Application for Planning Permission for Works or Extension to a Dwelling

Development: Single storey side and rear extension.
Location: 18 Ashmere Lane Felpham PO22 7QT

Drawing: Proposed Elevations.	
For: Penny & Jerry Spurr.	
Drawing Number: 1245.02.PI.	Revision: -
Scale: 1:50 @ A1.	Date: July 2026.

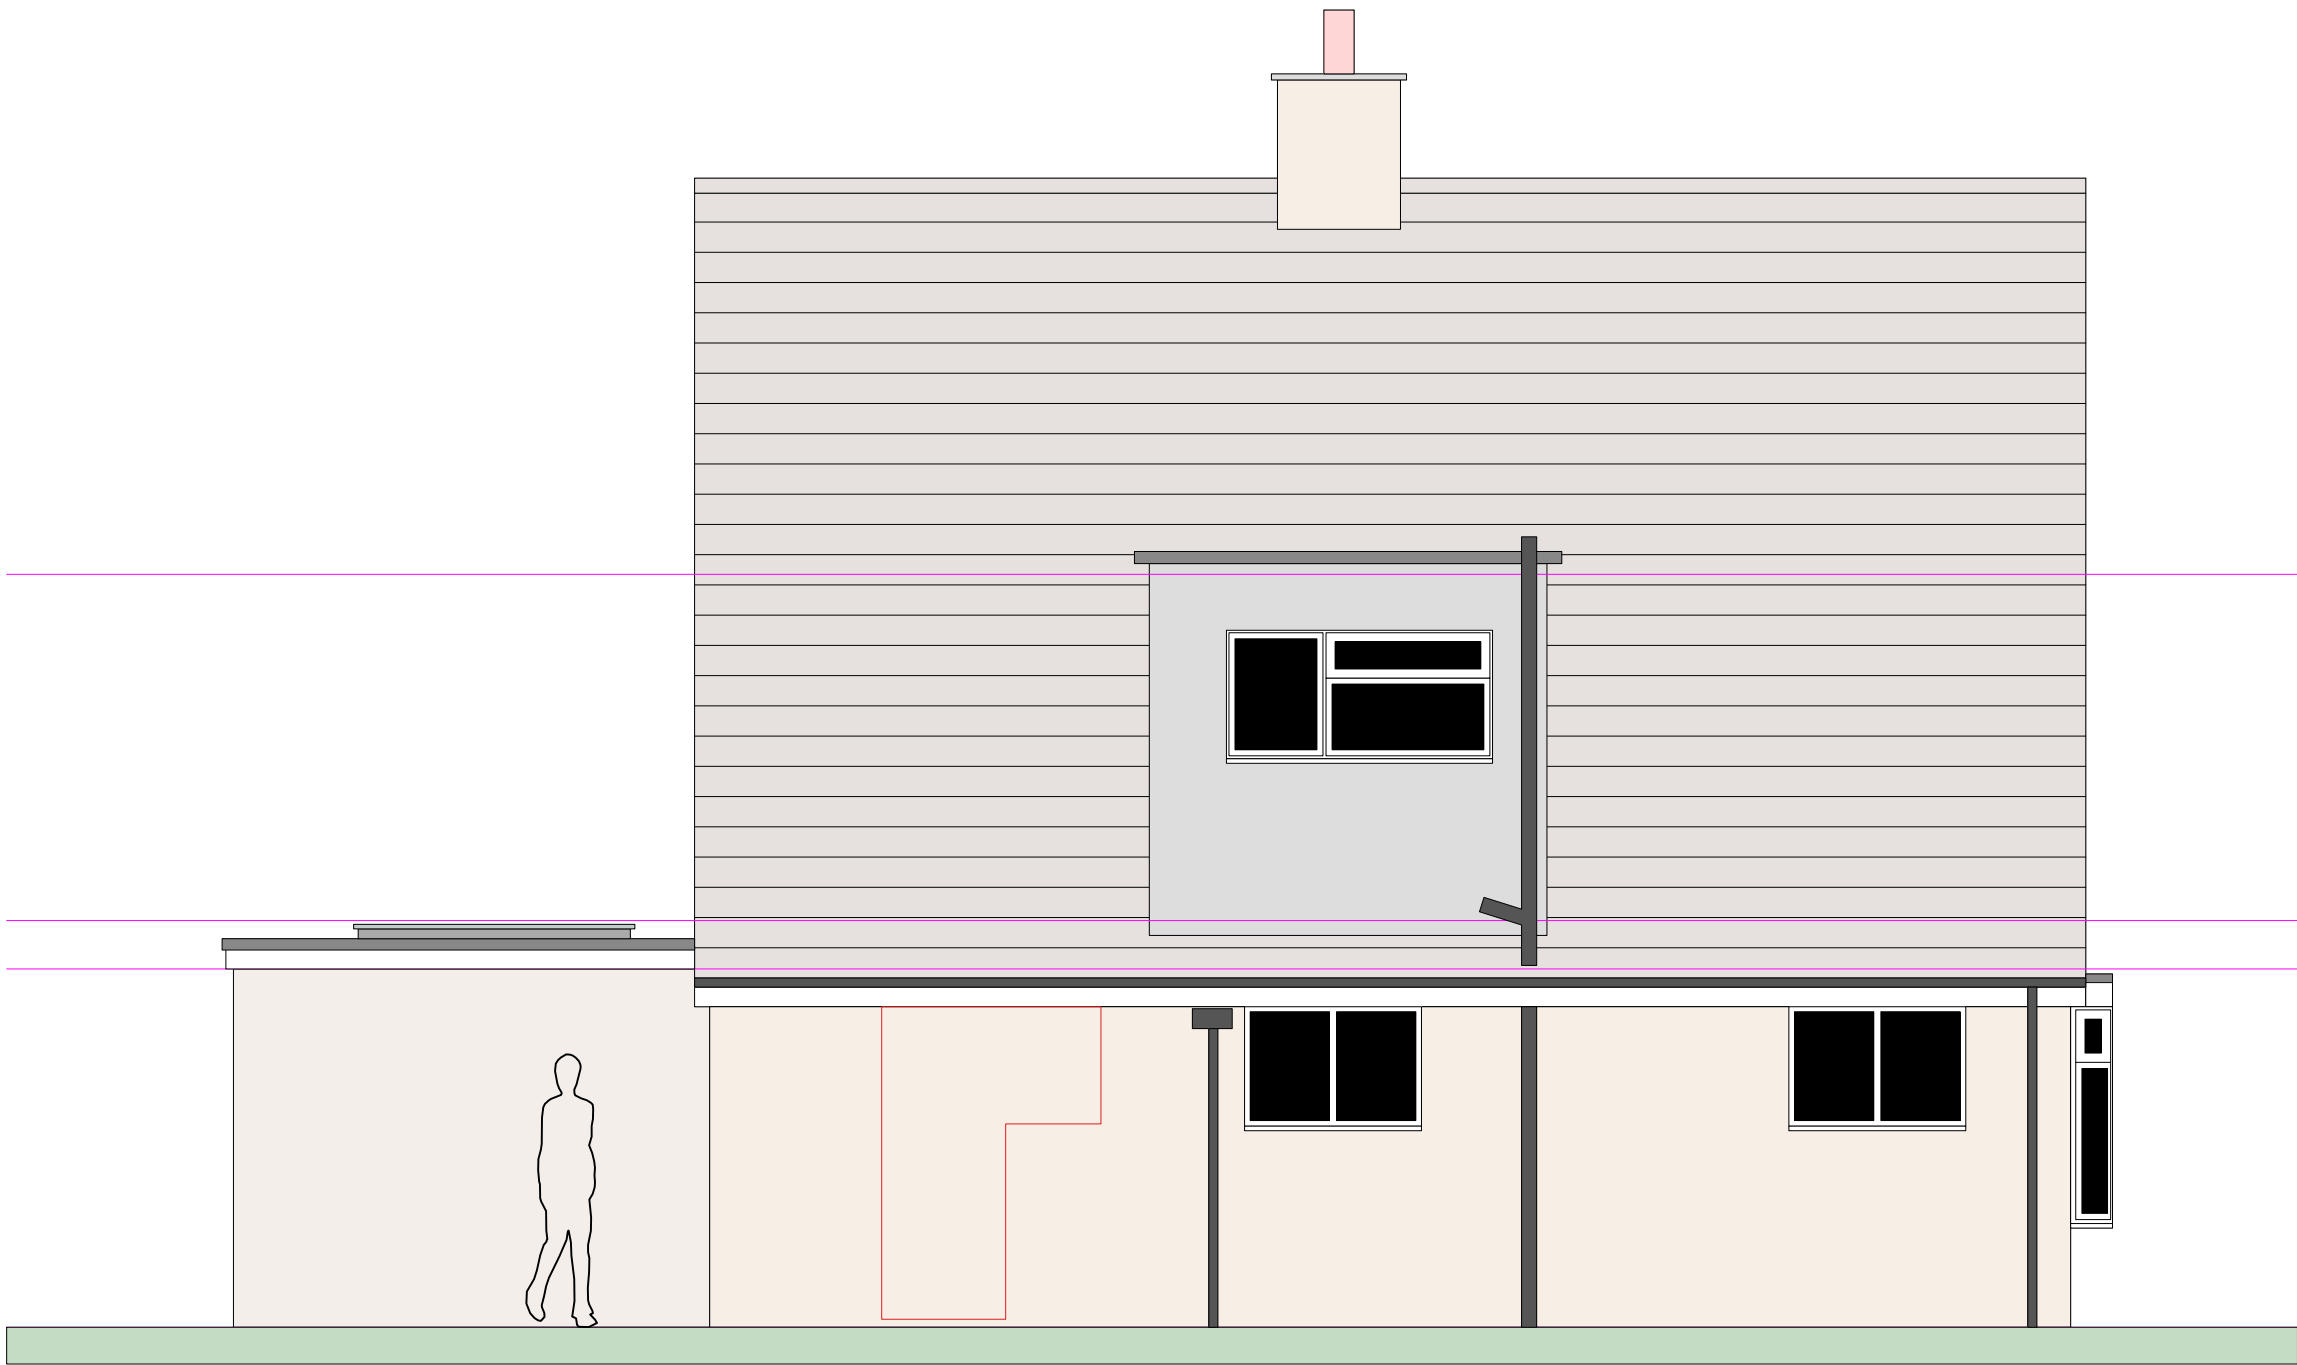
The existing south elevation floor plan window needs to be more clearly drawn as a window and the first floor north window.
